BEFORE THE KITTITAS COUNTY HEARING EXAMINER

In the matter of an appeal of the: Mitigated Determination of Non-significance for 3 BR Custom Cuts	CDS FILE NO. CU-23-0001 NOTICE OF APPEAL
---	---

Wilson Creek Neighbors, an unincorporated association of property owners, file this appeal of Kittitas County SEPA Responsible Officials *Mitigated Determination of Nonsignificance* issued February 7, 2024.

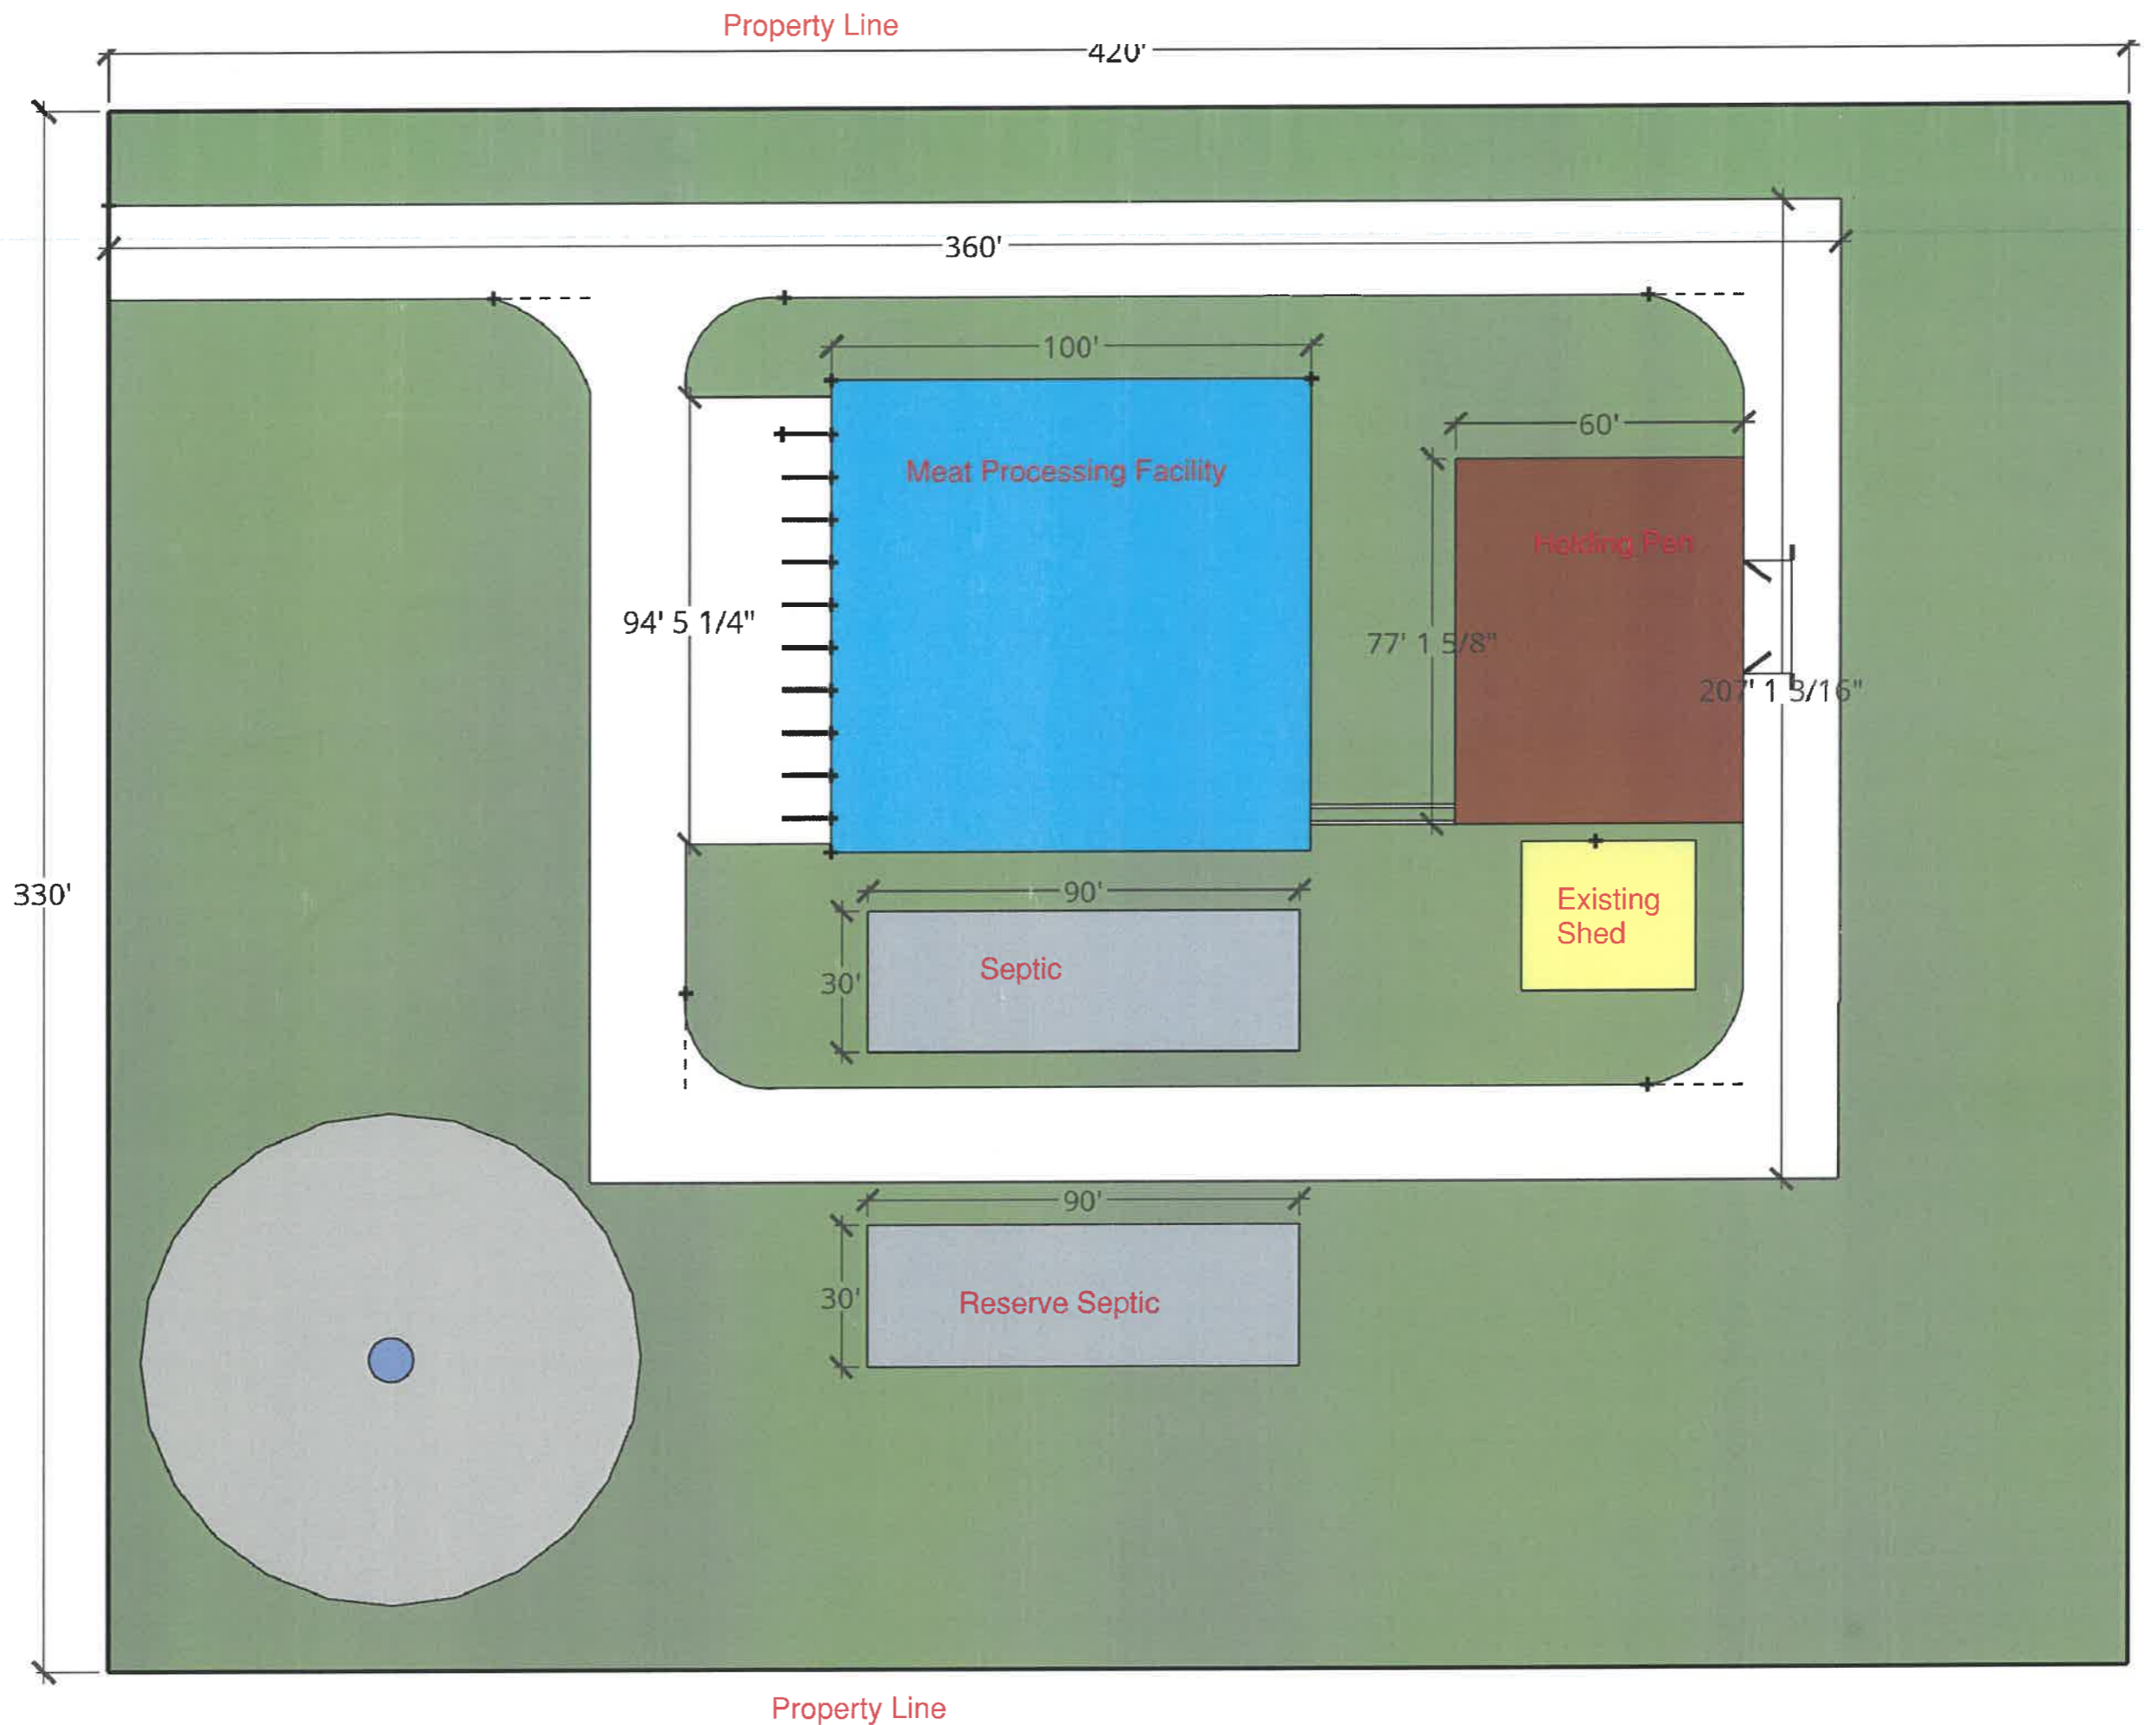
(a) SEPA Checklist does not include a current proposed site plan for the processing facility. Applicant filed an initial "site plan" for the proposed meat packing facility. Subsequent to initial submissions and comments, Applicant revised its project description and proposal. A substituted and incomplete site plan layout was included in the response materials which relocated access, modified structural layout, added parking areas, and introduced a new wastewater treatment facility. Drainfields were relocated to unidentified locations and no disclosure or identification was made with respect to land application disposal areas. The application lacks a detailed site plan that clearly identifies property lines, all project features and critical areas.

The site plan identifies that roadways will be placed directly on top of the existing well serving the property. Kittitas County Public Health Department specifically advised that any asphalt surface "...proposed within the 100 foot well radius represents a potential source of contamination..." and violates WAC 246-291-125(5). As proposed, the project cannot be constructed as depicted on the revised site plan. Any meaningful environmental review requires a complete and accurate site plan. "The written application shall be accompanied by a site plan

1 showing the dimensions and arrangement of the proposed development or changes including all
2 proposed land uses and structures; points of access, roads and parking areas; septic tank and
3 drainfield and replacement area; areas to be cut or filled; and natural features such as contours,
4 streams, wetlands, hazardous slopes, etc. The administrator may require other drawings,
5 topographic surveys, photographs, or other material essential to an understanding of the proposed
6 use and its relationship to the surrounding properties.” KCC 15A.03.030(2). The submitted site
7 plan is insufficient to identify and analyze environmental impacts of the proposed development.
